RE: 4000 Ellison NE
4000 Ellison Street NE
Grading and Drainage Plan
Engineer's Stamp Date: 4/17/22
Hydrology File: D17D074

Based upon the information provided in your submittal received 5/3/2022, the Grading & Drainage Plan is **not** approved for Building Permit. The following comments need to be addressed for approval of the above referenced project:

GRADING AND DRAINAGE PLAN

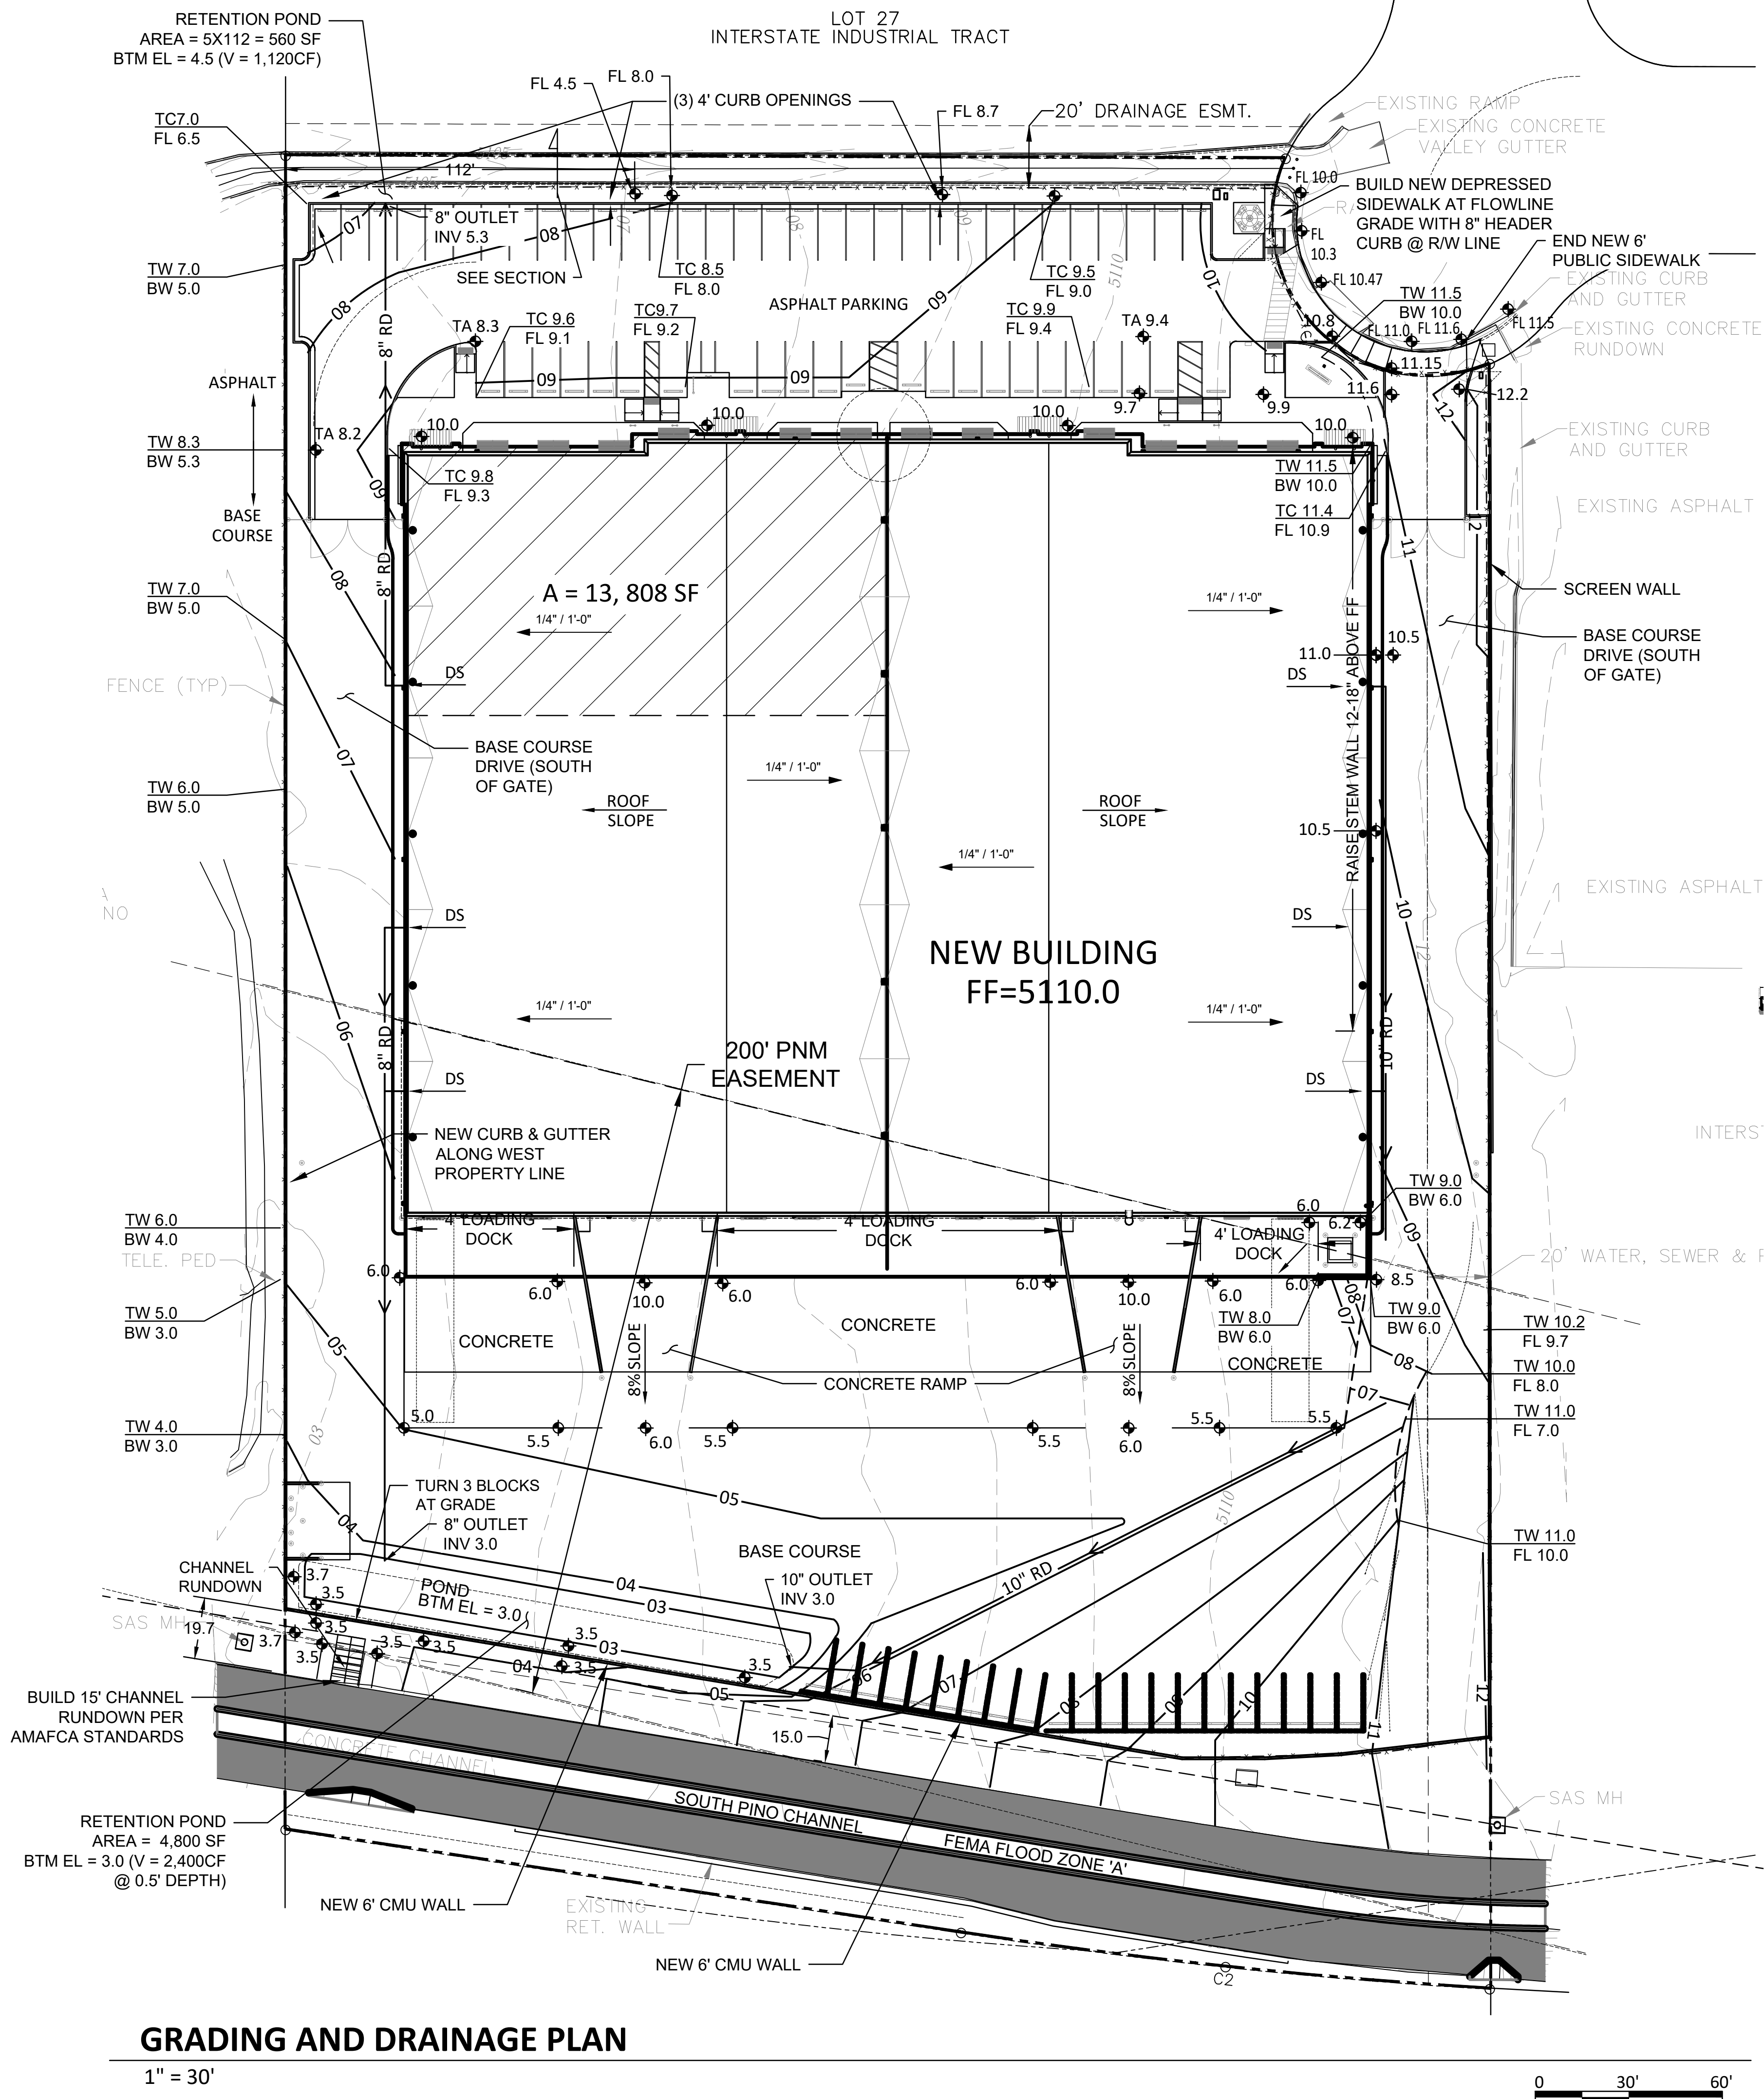
1. The proposed pond/channel will need to have fencing for safety per DPM.
2. Your proposed spot elevations still show a 3.5 feet deep pond it seems. Please clarify.
 - a. Please show the fence on the detail as well.
3. Please confirm with AMAFCA the site plan is acceptable. This site is close to their facility.
4. It looks like some of the site may be directed to adjacent site.
 - a. Please confirm this is not the case and clearly show on plan.
5. What is this? (Trash enclosure)

- a.
b. This is also assumingly a dumpster location above?
7. With a 0.5\" depth, will the pond really retain the SWQV necessary? (e.g. the outlet is 3.5 and the bottom depth is 3.0.
8. Provide cross sections of all ponds. (elevation of SWQV, outlet, and 100 yr elevation).

**SECTION A-A**  
1/4" = 1'-0"

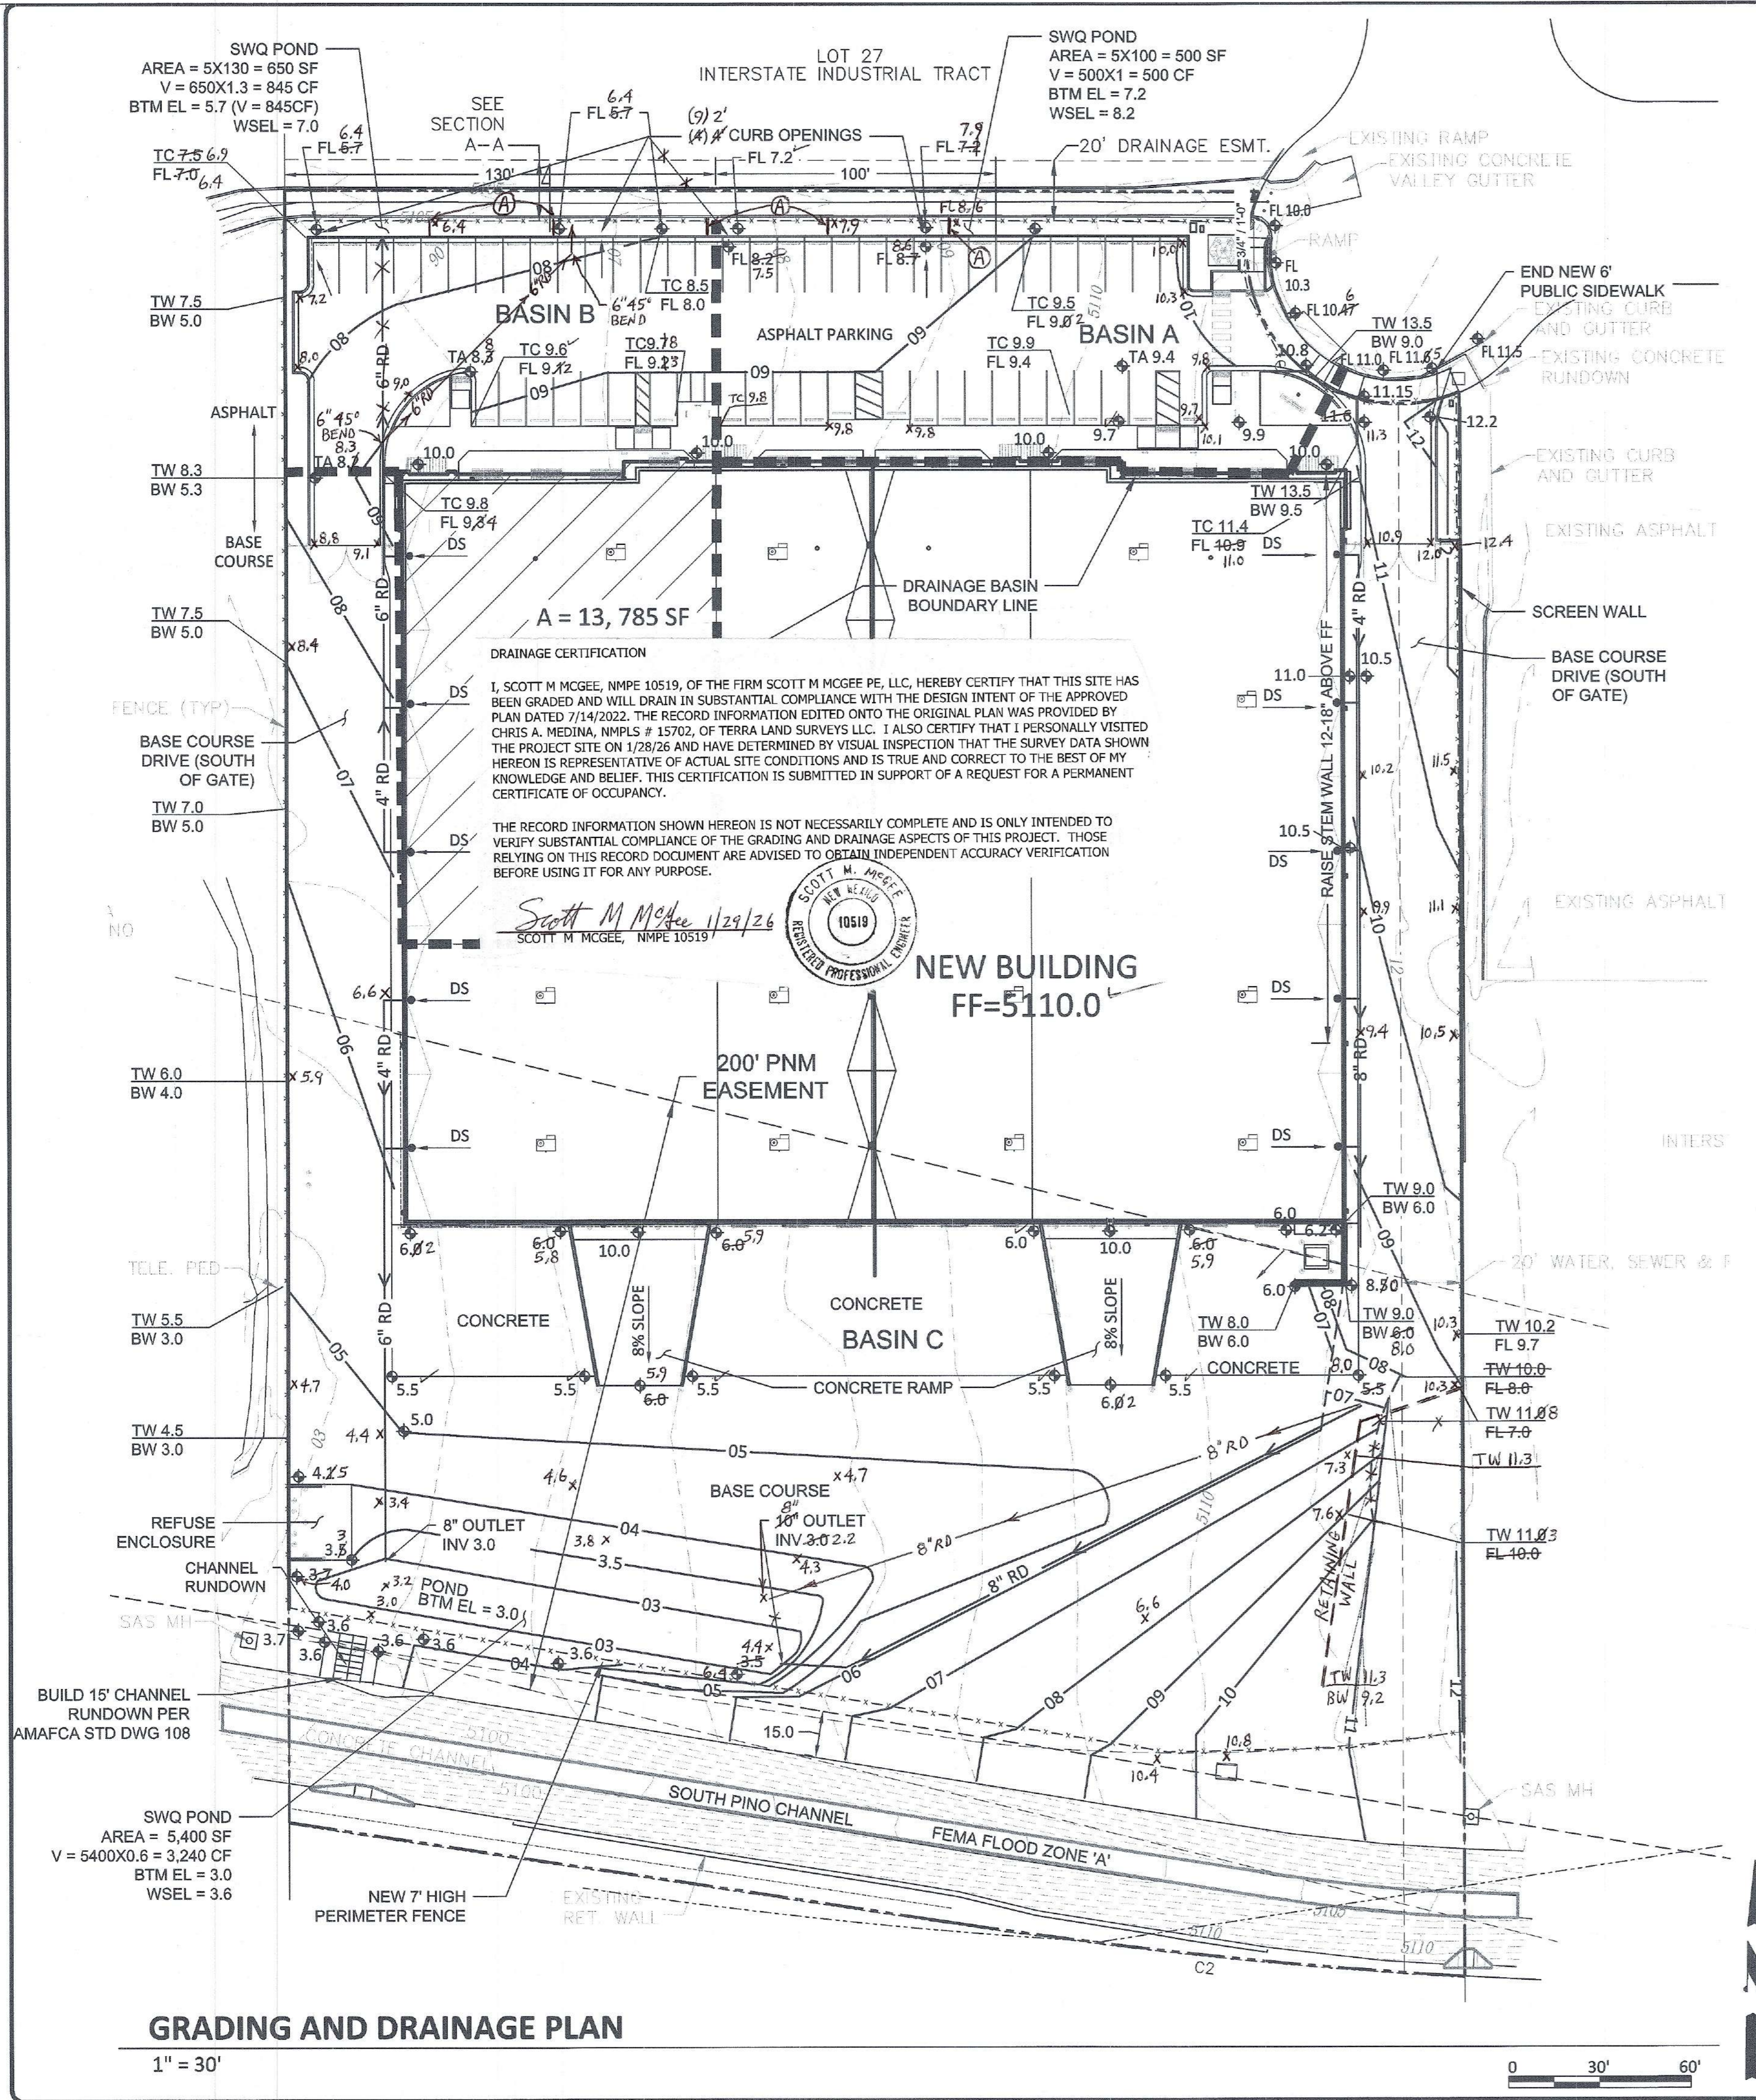
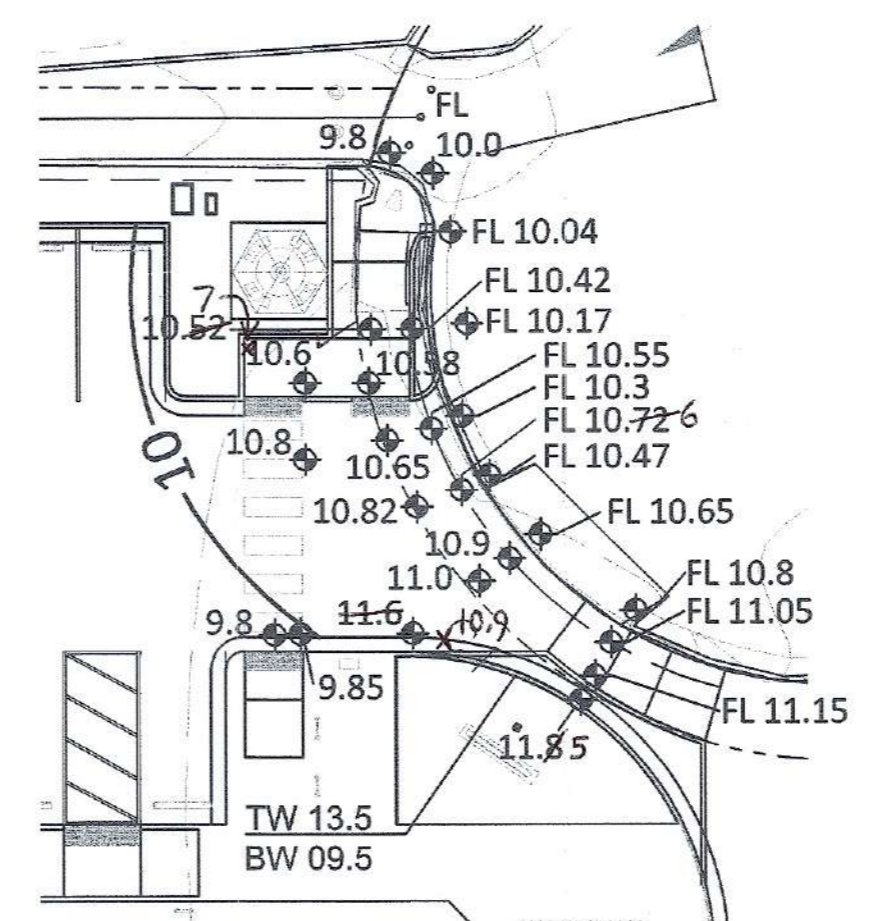
6. Please clearly show where this section is taken to relate to the plan (e.g. section A-A).
What is this a section of? (see picture below from plans)
